Permit Inspections Harnett County

Permit Number: BRES2312-0208

Description: total 12x30 additon =12x12 Sitting room 12x18 living room

Site Address: **18 PINERIDGE CV**

( 10" opening Detail )

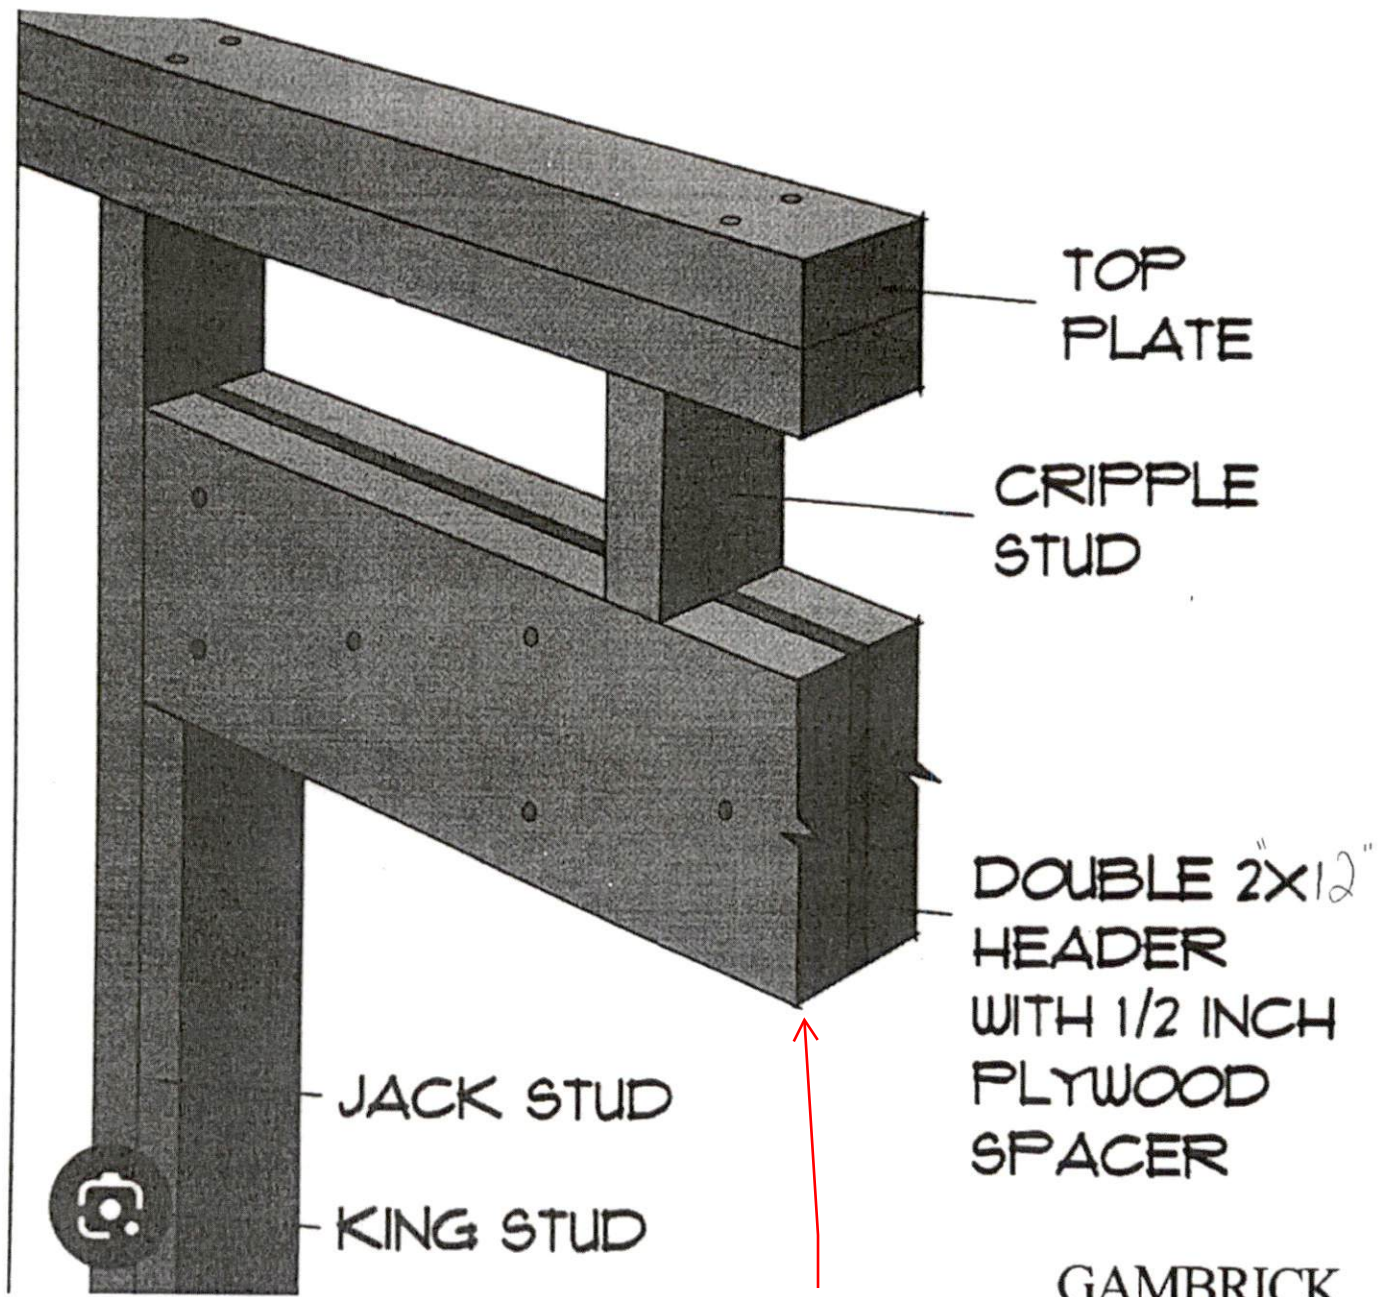
Notes: 1/ all window rating decals have been removed 2/ missing LVL at 10' opening. 3/ roof slope min 3 - 12 verify required underlayment. 4/ need header over existing crawl opening. Ok to insulate
